A57 Link Roads

**8.2 Draft Statement of Common Ground
with Tameside MBC**

A57 Link Roads Development Consent Order 202[x]

Table 3.1: Statement of Common Ground (SoCG) Between National Highways and Tameside Metropolitan Borough Council Tameside Metropolitan Borough Council (TMBC) Table of Issues/Matters - Final Version dated 5 November 2021

**6.4 Environmental Statement  
Figure 8.6i Breeding Bird Survey Plan**

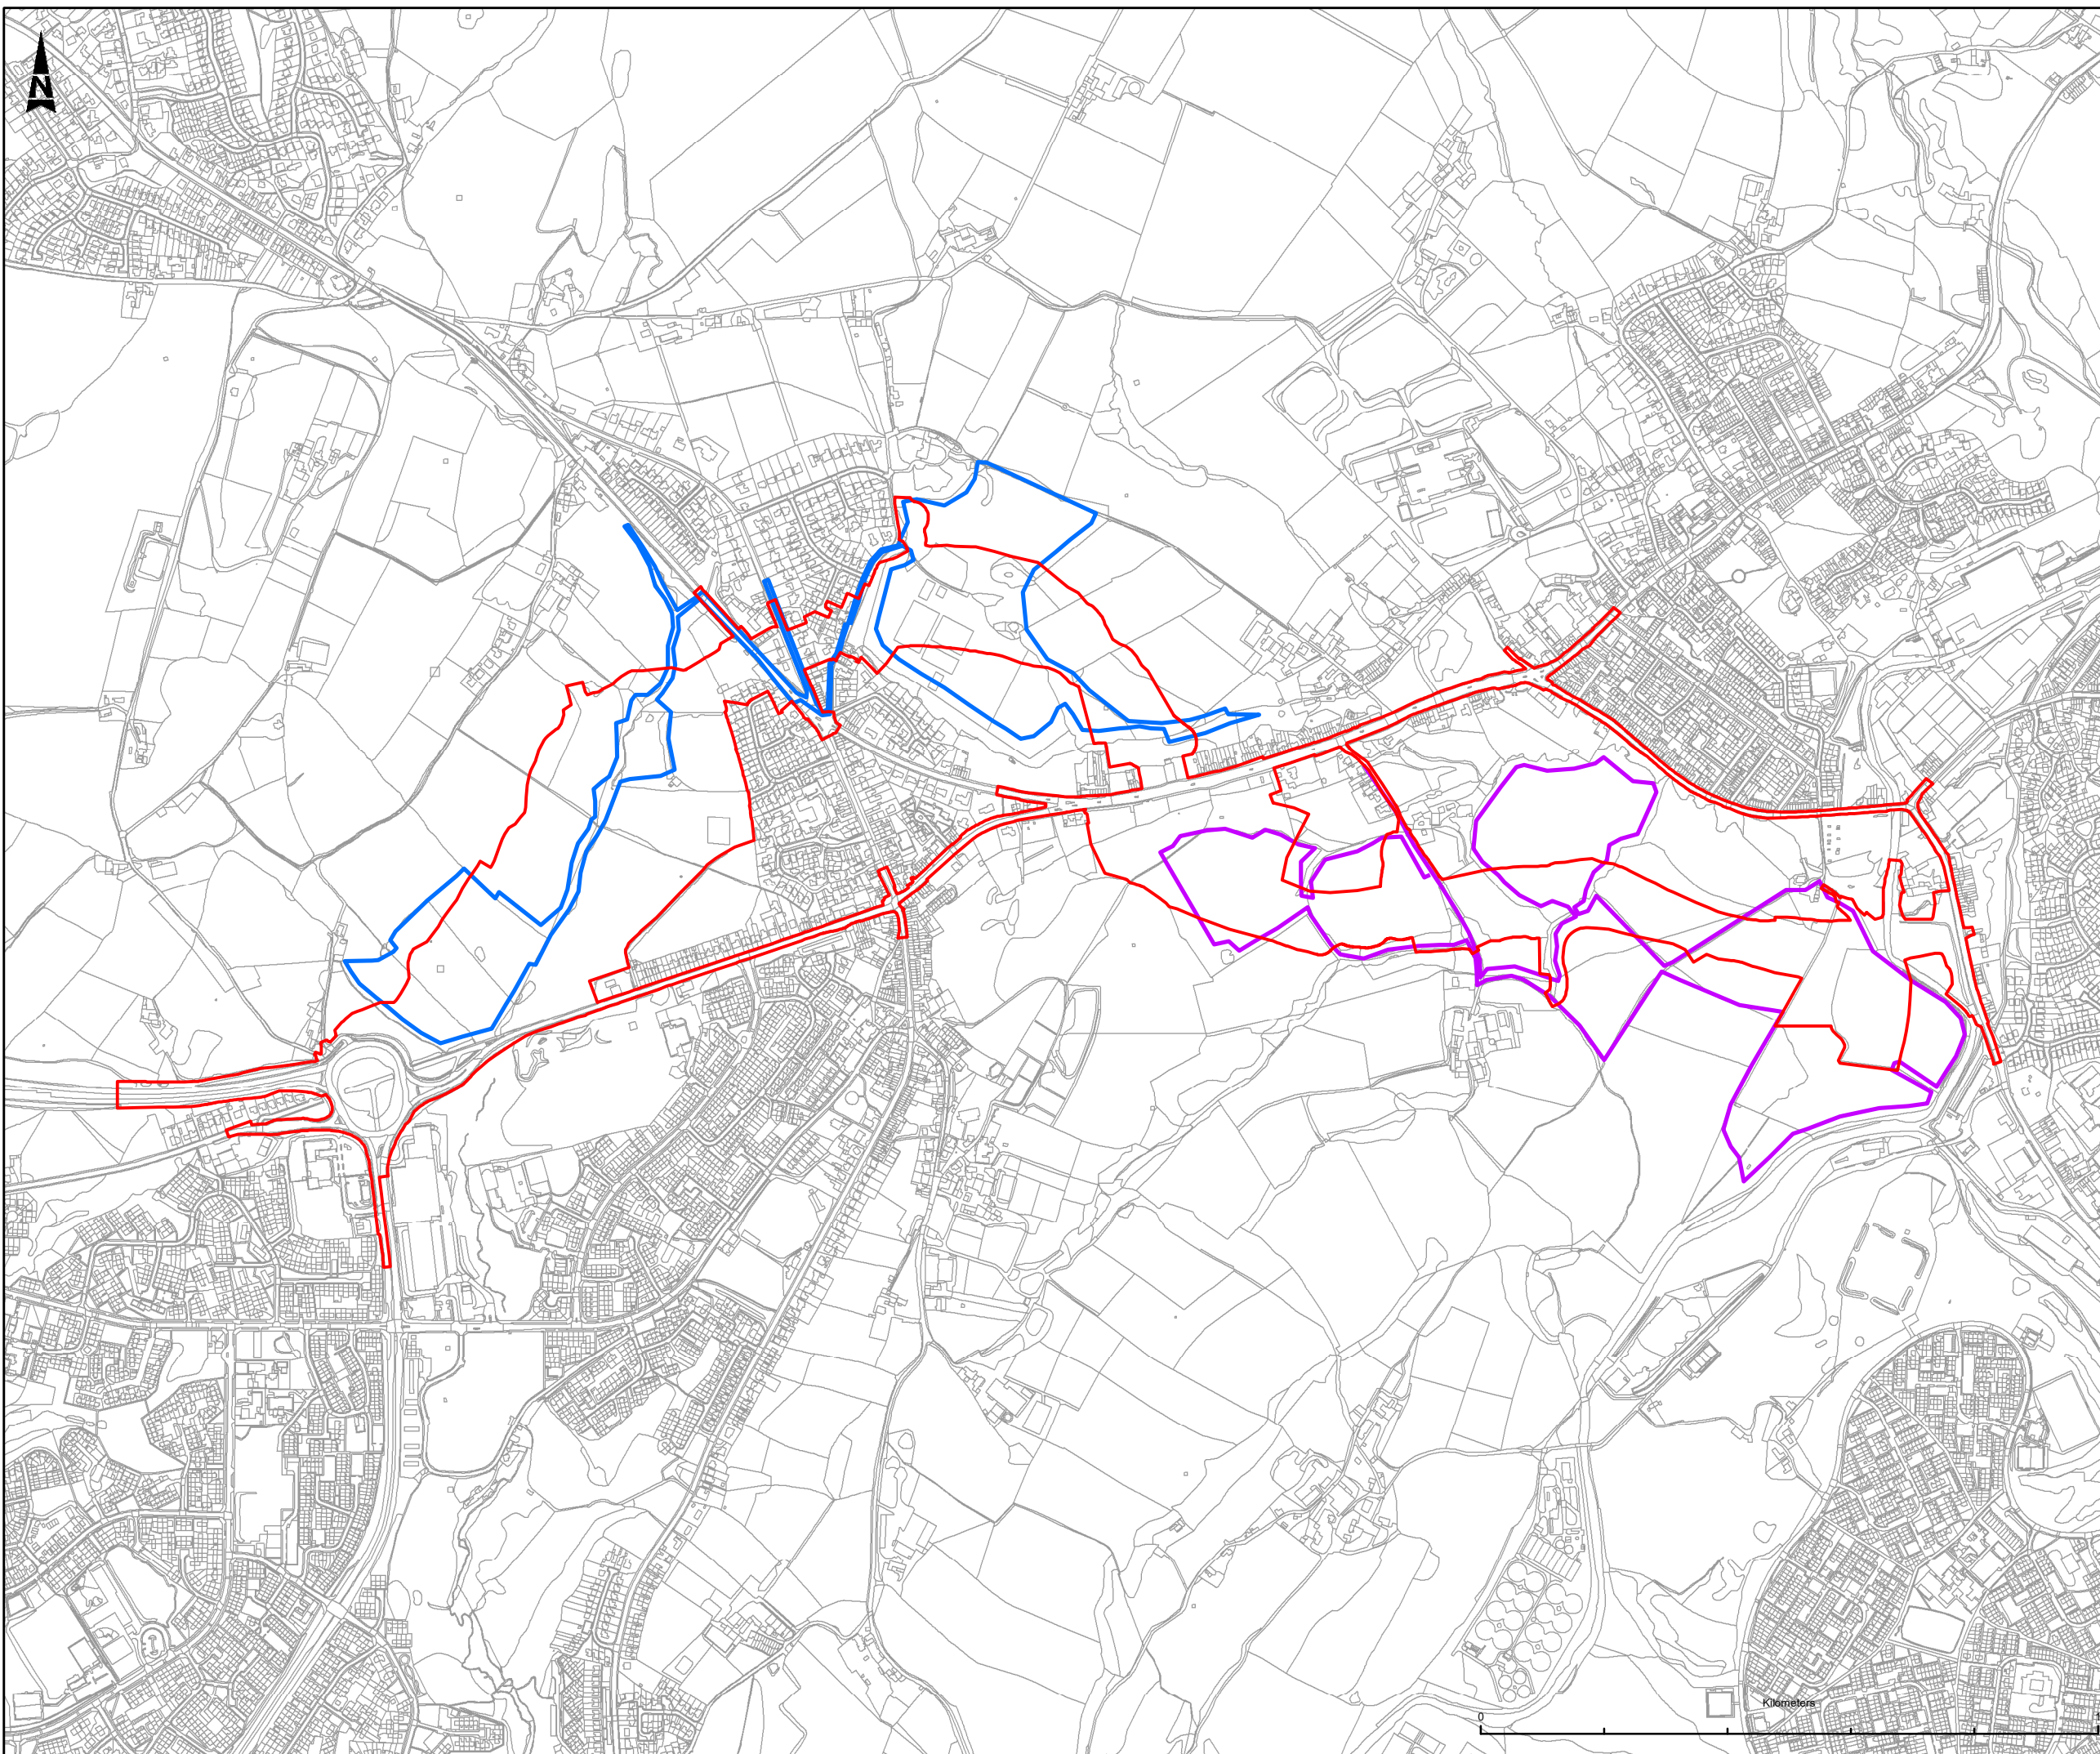
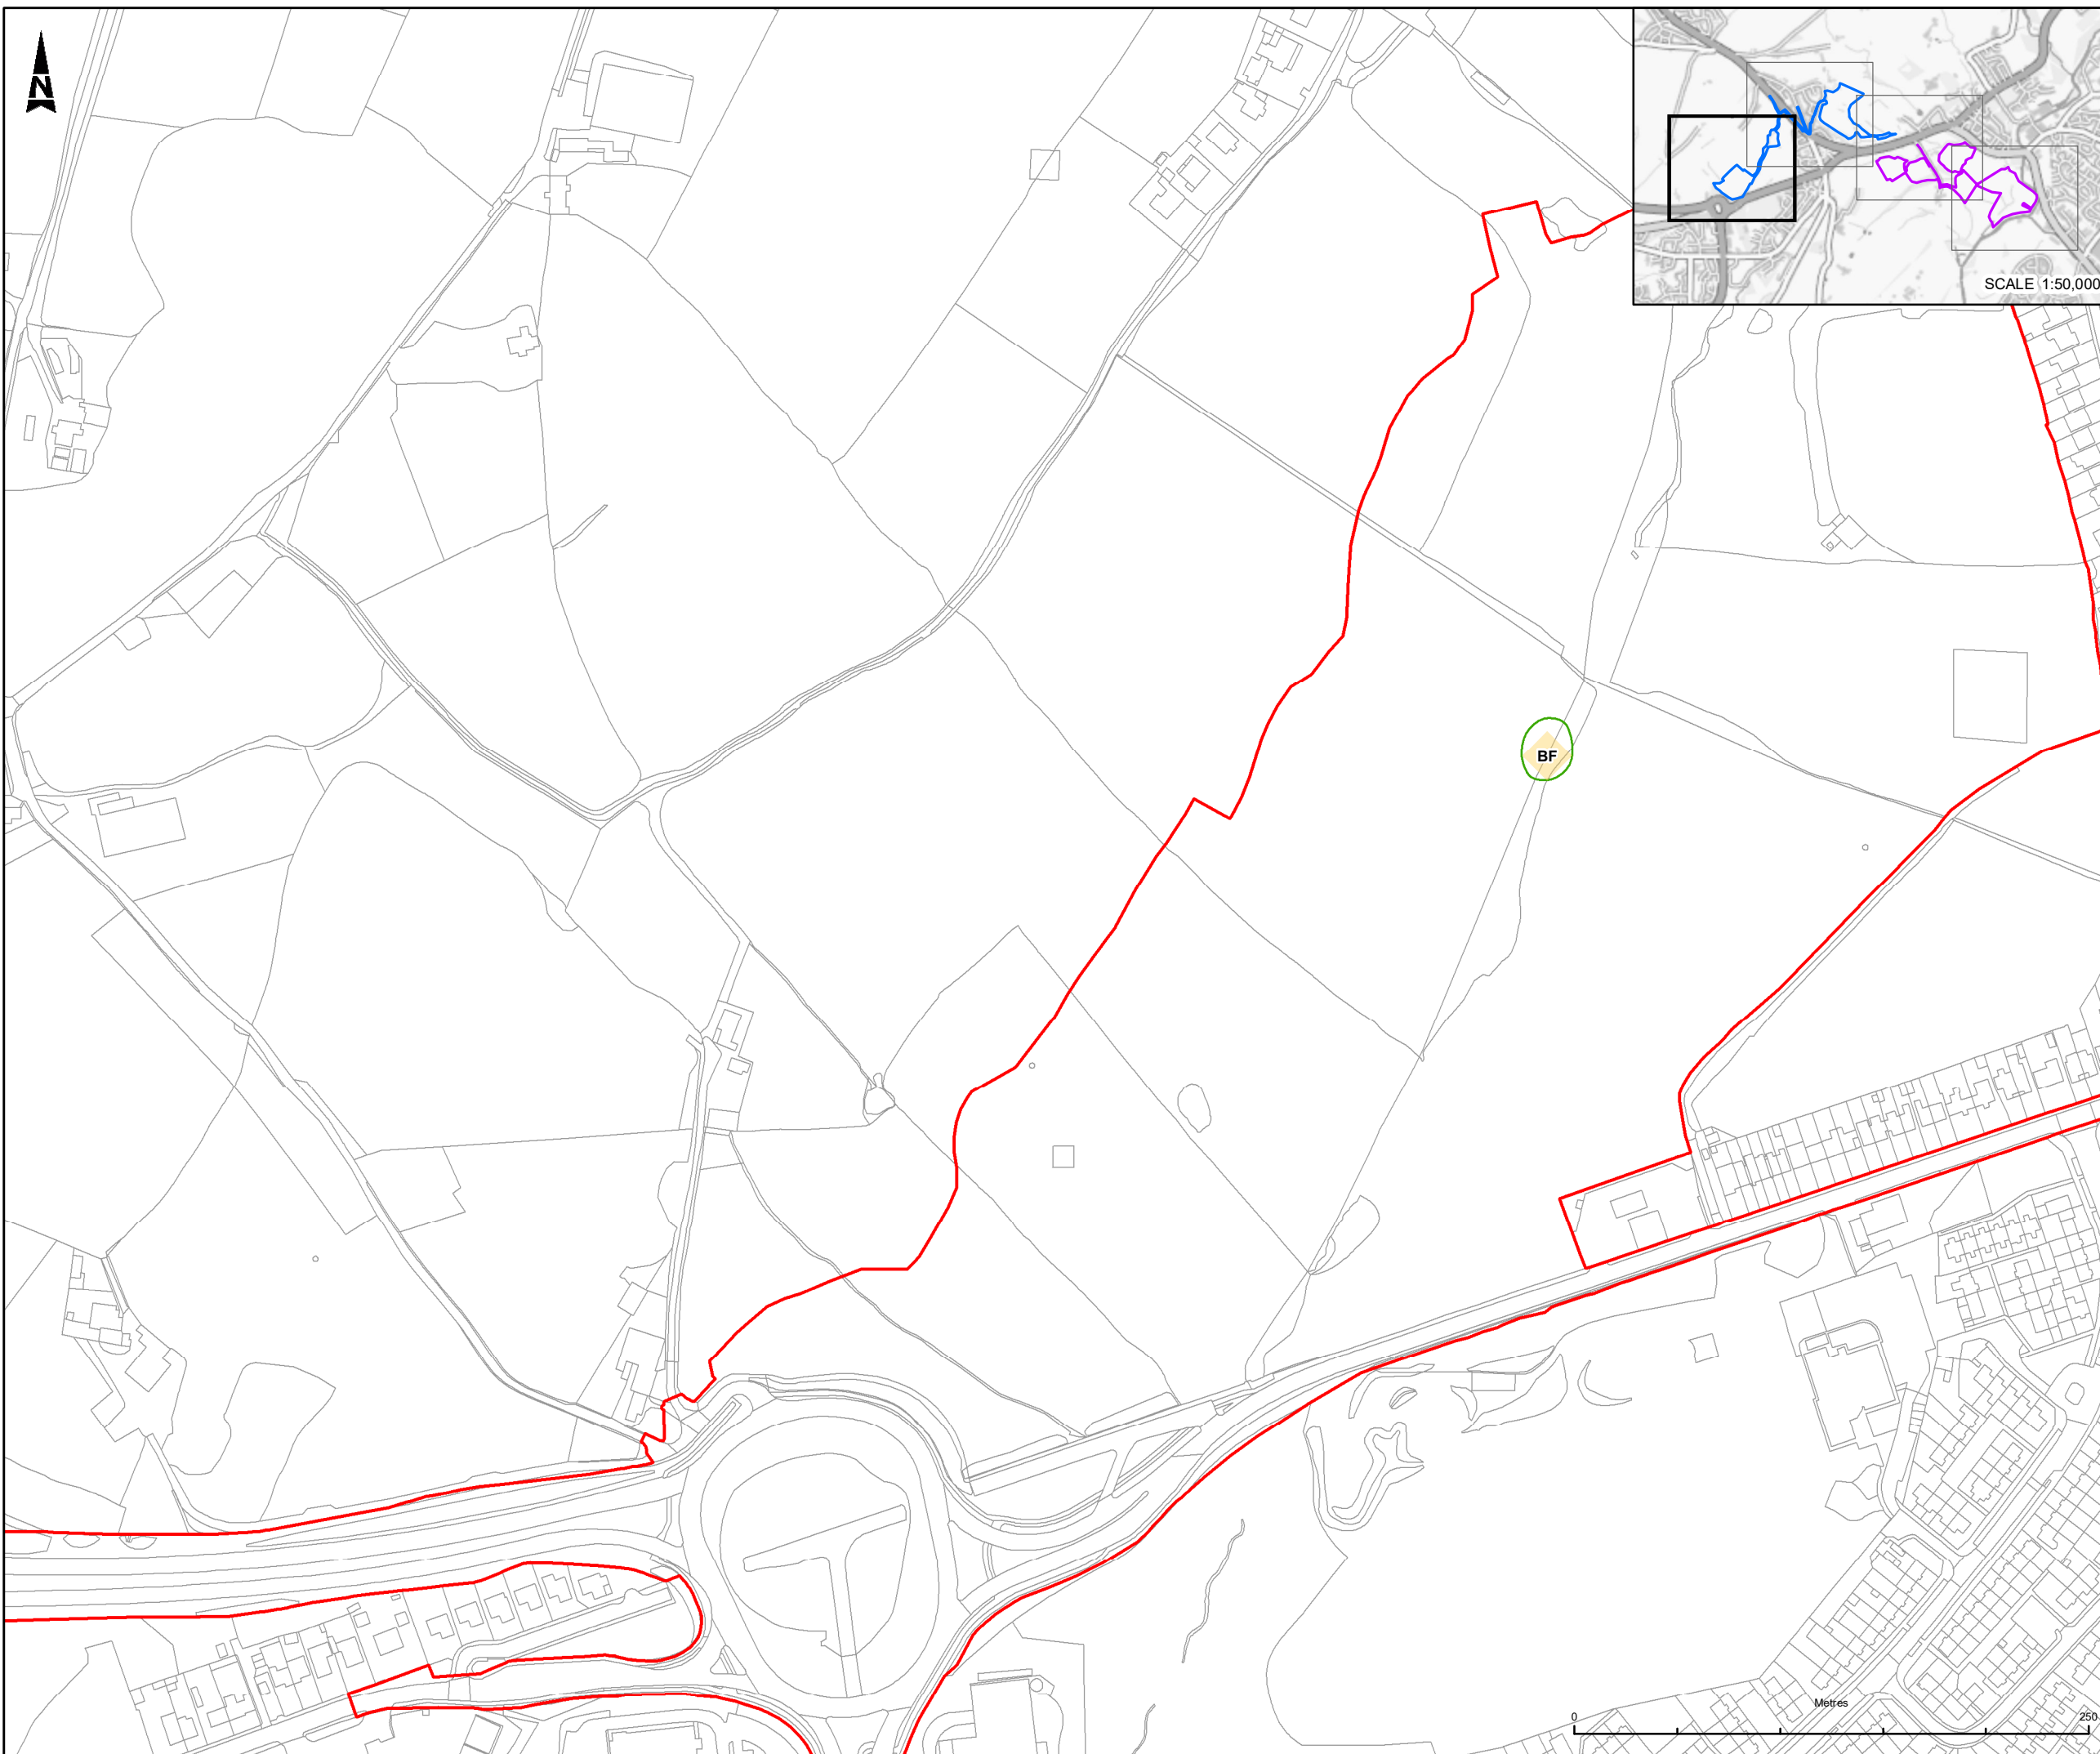
3.2	<p>Environmental Statement (ES) – Chapter 8 - Biodiversity [APP-064]</p> <p>Environmental Statement</p>	<p>Biodiversity</p> <p>Protected species</p>	<p>The Consultee stated that it would like to see the survey results, specifically regarding breeding birds. It described how protected species support is informally divided by organisation.</p>	<p>Breeding bird surveys have been undertaken throughout 2020 supported through desk studies. Full detailed results (including methodology) will be provided within the ES. Applicant noted contact. The methodology has been agreed with Natural England</p>	Agreed

SoCG Ref. Number	Relevant examination document	Relevant Issue	TMBC comment	National Highways response	Status
	(ES) – Appendix 8.1 – Biodiversity Baseline and Preliminary Assessment [APP-169]			National Highways to ensure ES has been shared.
